**Application Reference:** 2025/0482

**Site Address:** 21 Locke Avenue, Barnsley, S70 1QH

**Introduction:** Erection of a raised rear balcony

SIDE VIEW WITHOUT BALCONY

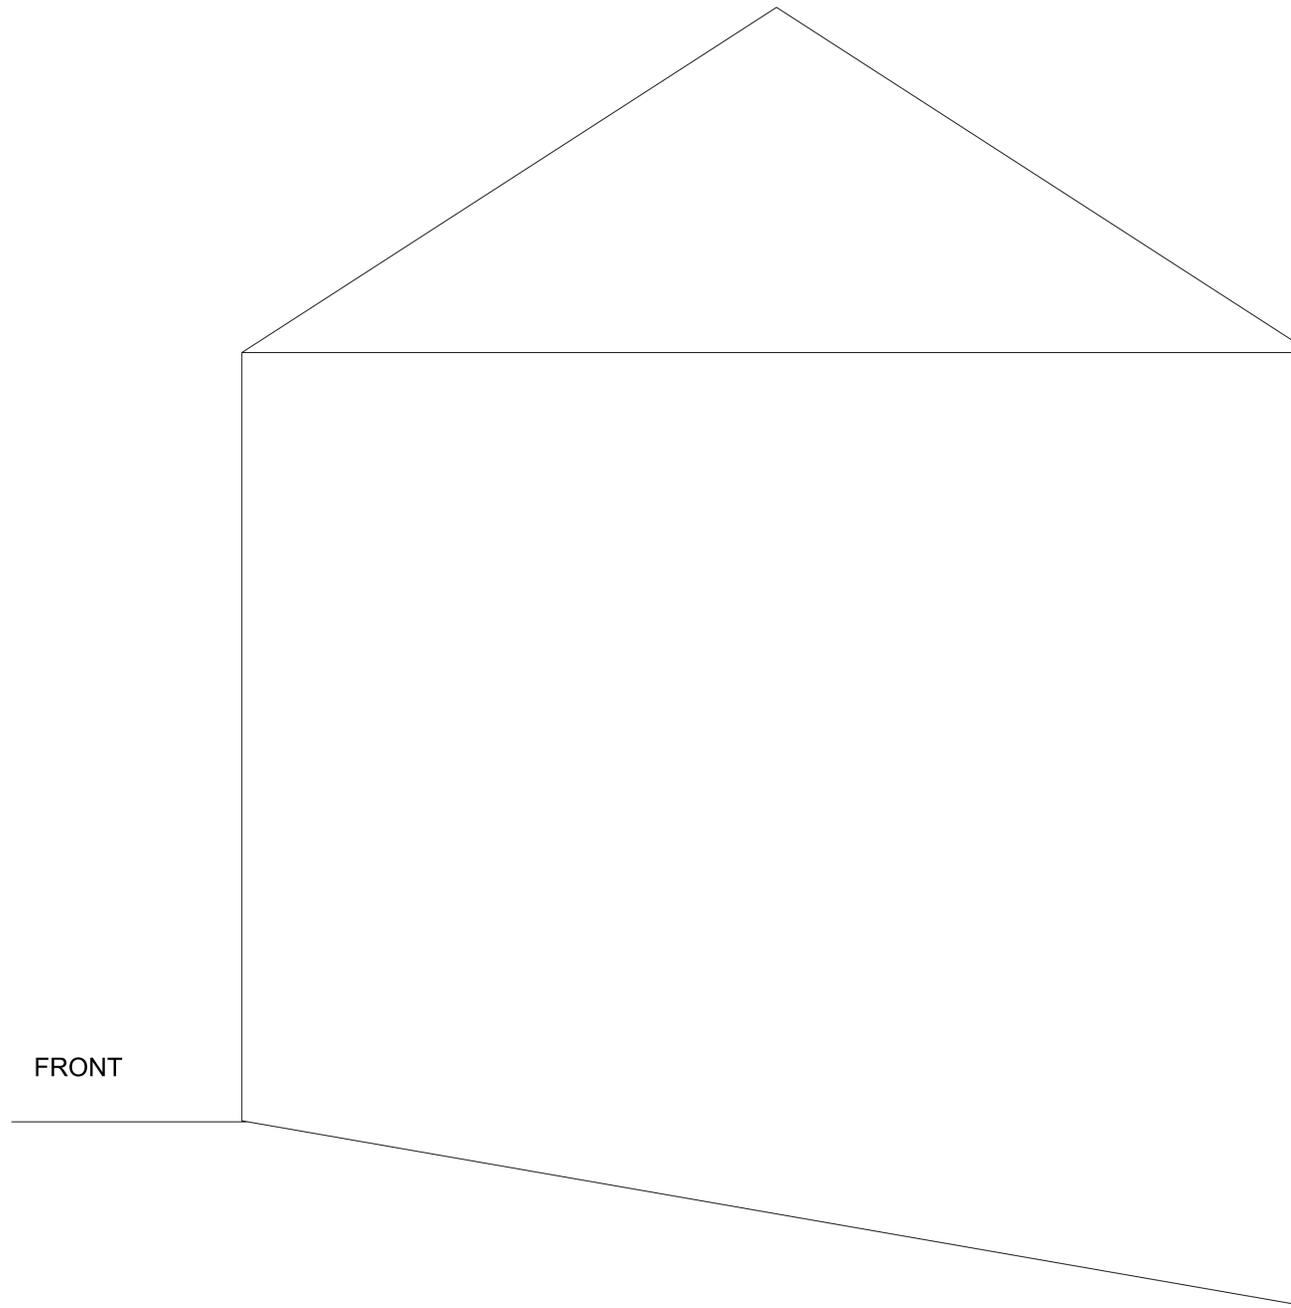
The applicant is seeking permission to erect a rear balcony. The balcony would service the middle floor of the rear of the dwelling, however due to the topography of the site would be the ground floor for the front elevation of the dwelling. The balcony would provide a rearward projection of approximately 3 metres and an approximate width of 8 metres which would span the entirety of the rear elevation. The balcony would have a floor height of approximately 2.8 metres and would utilize 3 steel frame columns to support the balcony. The proposed balcony would detail a glass balustrade surrounding the whole of the balcony with a height of approximately 1.1 metres. The plans also detail two sets of french doors to provide access to the balcony.

Contract No:	001	Contract Title:	Rear Balcony
--------------	-----	-----------------	--------------

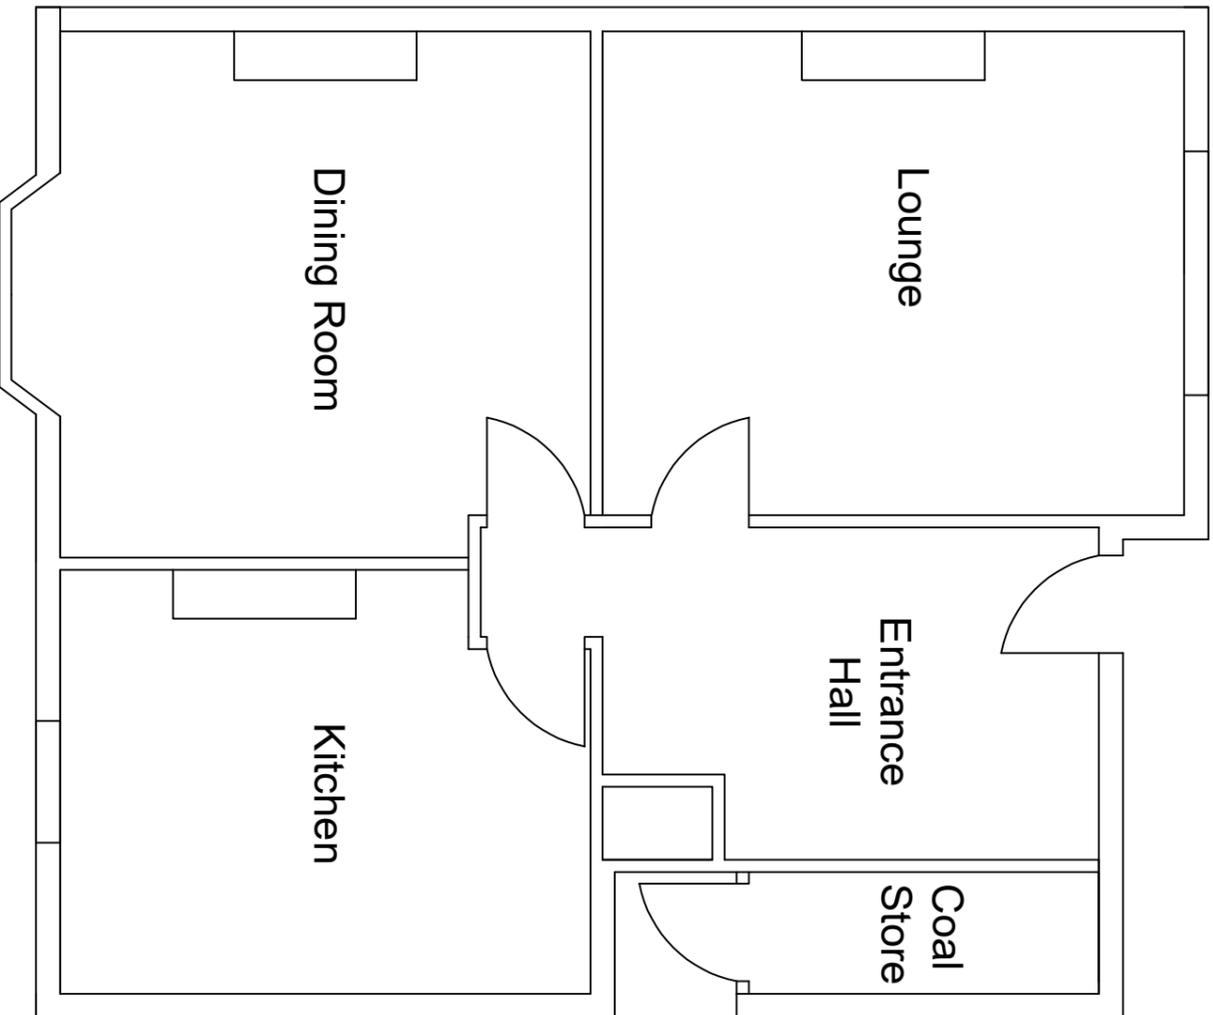
The proposed rear balcony provides a substantial rearward projection of approximately 3 metres. Although this would not be seen from the street scene this would be out of keeping with the character of the dwelling and can be seen from the alley to the rear of the site where access is provided. Despite this, on balance the proposal would not detrimentally detract from the visual amenity of the dwelling.

Some raised platforms can be considered acceptable when providing access to the rear garden of a dwelling in order to provide a convenient outdoor amenity space. In this case no access from the balcony has been provided and so the proposal does not assist with rear garden access. As outlined with the House Extensions SPD, decking in prominent locations is not allowed. The proposal details 'beige composite decking' which would be located at an elevated position and would detract from the visual amenity of the dwelling.

Although the scale of the proposal would not significantly detract from the visual amenity, it is considered that the proposed balcony decking materials would detract from the visual amenity and therefore not be acceptable and conflicts with Local Plan policy D1: High Quality Design and Place Making and as such carries limited weight in favour of the application.

The proposed balcony provides a significant projection of approximately 3 metres and approximate width of 8 metres. This provides a floor space of 24 square metres. This is considered a significant area for which gathering of multiple people could occur. The proposed balcony would allow occupants much more freedom to move outside of the building and into an elevated and open position which would undoubtedly increase external activities and usage. This would also increase overlooking of neighbours and noise disturbance.

Given the proposal is at a significant height above neighbouring rear amenity space, the proposal would allow for substantial levels of overlooking. The proposal would be approximately 3 metres distance from neighbouring boundaries to the north and south. This would allow for detrimental levels of direct overlooking which would be amplified with the occurrence of any gatherings given the large floorspace of the proposal. The balcony would additionally face the rear amenity space of properties on Blenheim Road. An approximate distance from the balcony of 14 metres would be maintained. Although a rear garage is evident within 110 Blenheim Road directly to the rear of the proposal along with rear garden walls to other neighbours, given the topography of the site, the proposed balcony would be at such a height which would allow for overlooking into the rear amenity space of rear neighbours and potential for overlooking into the second floor of these properties. Overall, the proposed balcony would be positioned in a location which would allow for detrimental levels of overlooking to neighbours to the north, south and rear of the site.

It is therefore considered that the proposal would result in a significant increase in overlooking to a detrimental level and is not in compliance with Local Plan Policy GD1 General Development. This carries substantial weight in opposition of the application.
